**Consultation Response from KC,
Policy**
2022/92882 749, New Hey Road, Outlane, Huddersfield, HD3 3YL
Conversion and extension of existing Listed barn to form one dwelling, part demolition and conversion of existing barn to form one dwelling and erection of one new-build dwelling with associated car parking and external works [Listed Building]
Date Responded:
Responding Officer:
Responding Ref:

This proposal is for the conversion and extension of existing listed barn to form one dwelling, part demolition and conversion of existing barn to form one dwelling and erection of one new-build dwelling with associated car parking and external works at 749, New Hey Road, Outlane, Huddersfield, HD3 3YL.

GROUND FLOOR PLAN
HOUSE-TYPE C - CONVERTED BARN

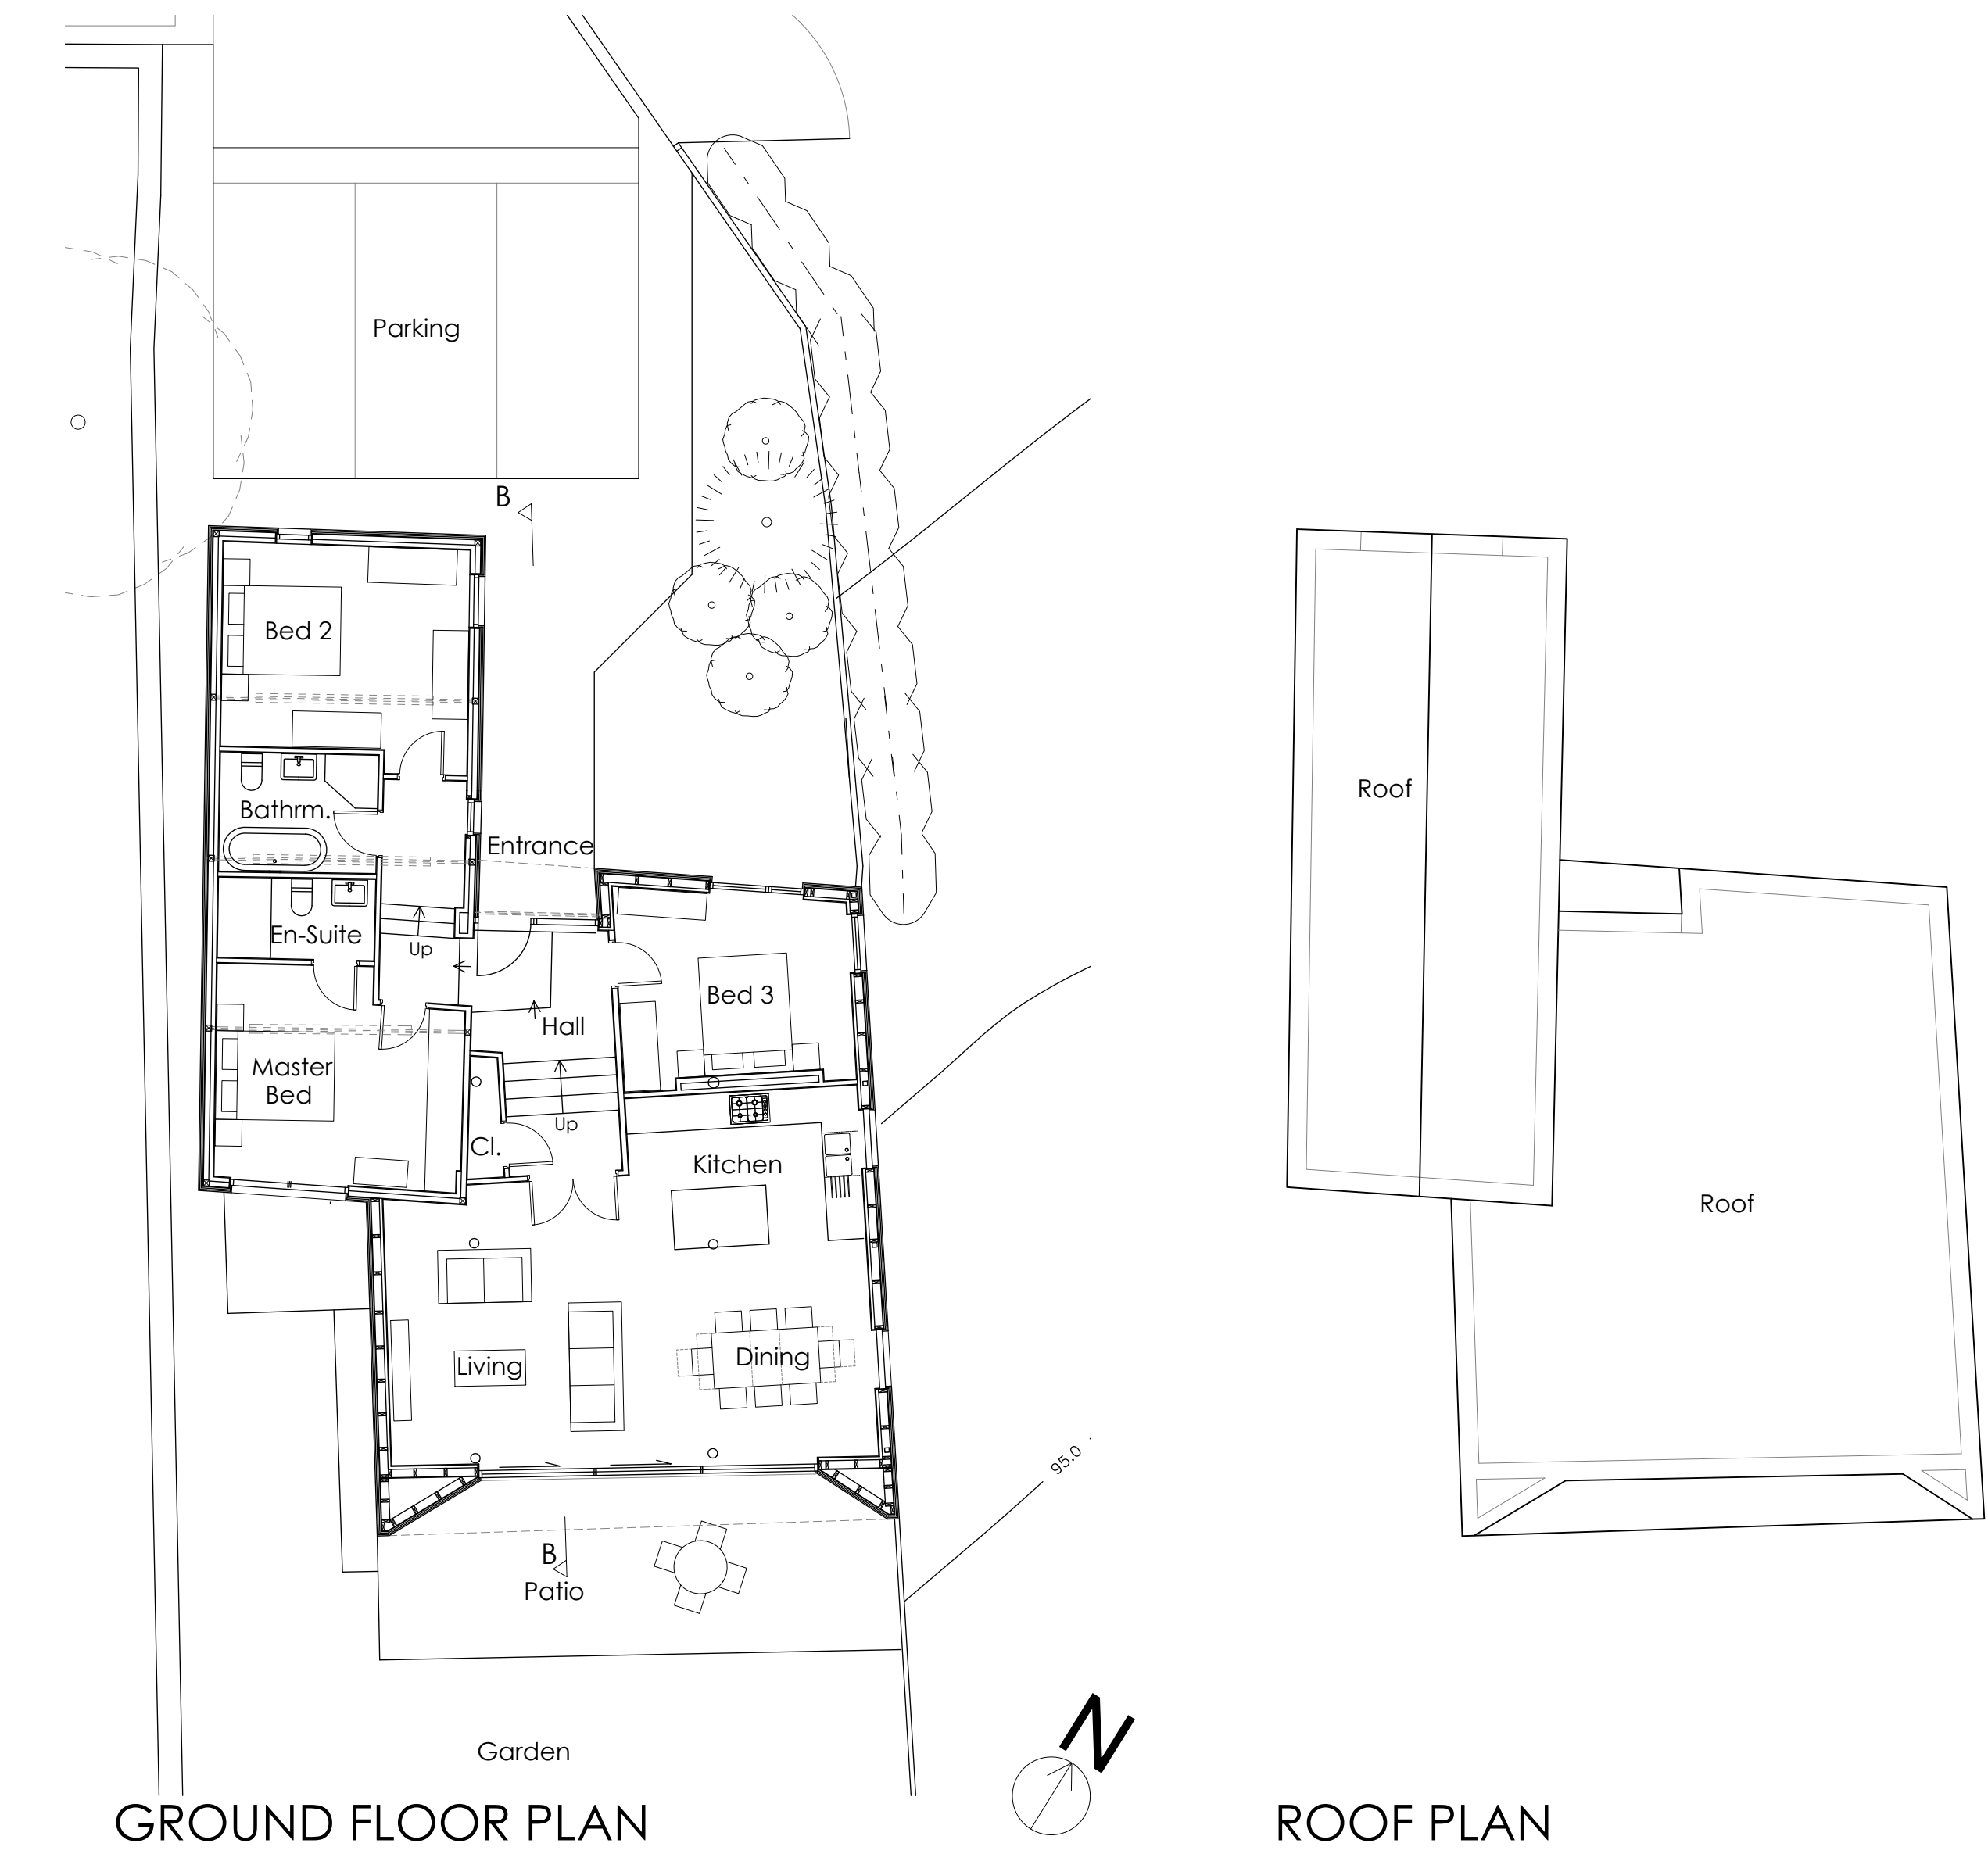
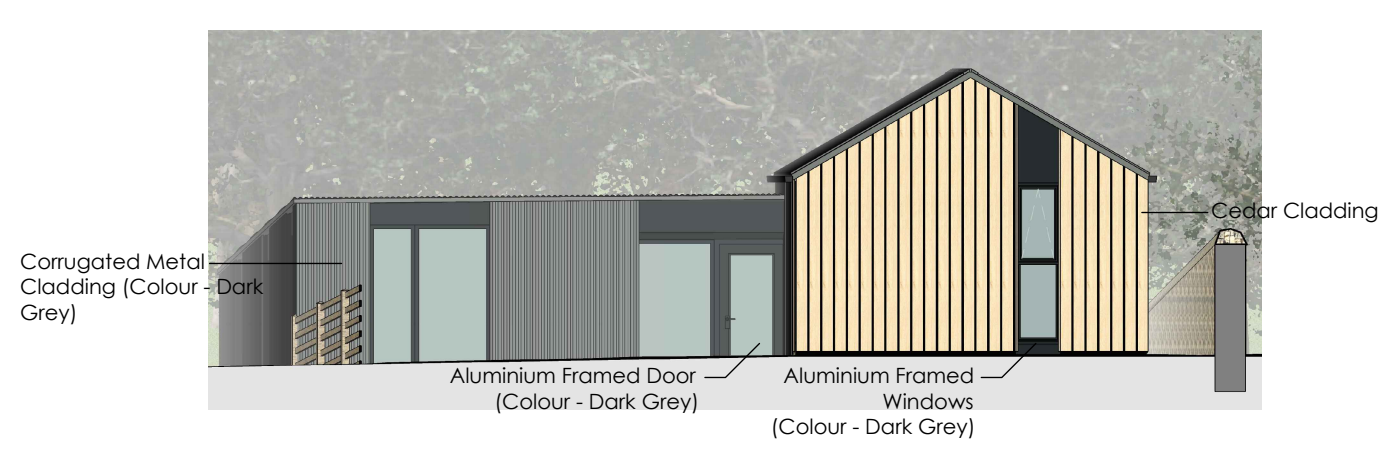
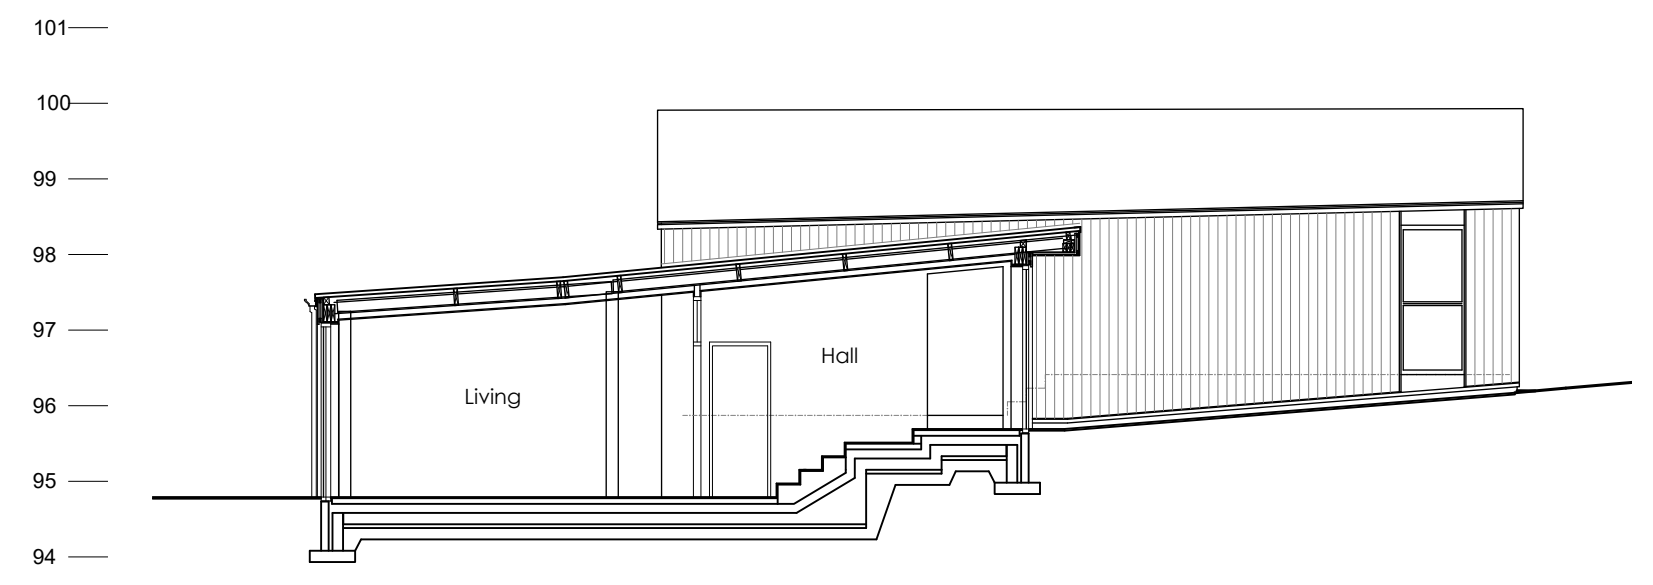
It should be noted that the pole barn and attached shed proposed to form the fourth dwelling is situated in the Green Belt, **and** the curtilage of the listed barn impinges on Green Belt land, therefore the scheme must be assessed against Green Belt policies in the NPPF and Kirklees Local Plan.

In this case, site photos and a structural appraisal report confirm that the pole barn and attached shed are two integrated structures – a duo-pitched timber framed shed/barn type building, with an attached mono-pitch barn constructed using steel and timber. The structure previously accommodated livestock when the site was a working farm, however it is now redundant and dilapidated. It is evident from the

site photos that the structure is in a complete state of disrepair, appearing to have large holes in both the walls of the mono-pitch barn and the duo-pitched shed.

With this in mind, it is not considered the building is of 'permanent or substantial construction' that would permit a satisfactory conversion to form a residential dwelling under paragraph 150 criterion d) of the NPPF or LP60 criteria a) without major or substantial reconstruction. Although the planning statement details that the proposed redevelopment of the barn/shed would reduce the bulk, scale and mass of the original building to provide for a smaller building, replacing a building that is not of permanent or substantial construction with a permanent structure, even a smaller one, fails to accord with national and local green belt policy. Paragraph 19.36 of the Kirklees Local Plan states that replacing a building of a temporary nature with a more permanent structure is not normally supported, as development of this type holds the potential to harm the appearance, and openness of the Green Belt.

In addition to this, the proposal conflicts with the purposes of including land within the Green Belt, and fails to accord with criterion b) of Local Plan policy LP60. As explained in paragraph 138 of the NPPF, one of the purposes of including land within the Green Belt is to assist in safeguarding the countryside from encroachment. The existing structure is agricultural, and is currently positioned within what appears to be an unused, open paddock and is therefore appropriate to its setting. The substantial reconstruction that would be necessary to provide a permanent residential dwelling will constitute encroachment into the countryside, through the introduction of incongruous domestic or urban characteristics of a permanent nature into the landscape – meaning such development would fail to be in accordance with NPPF paragraph 150 and LP60 criterion b).
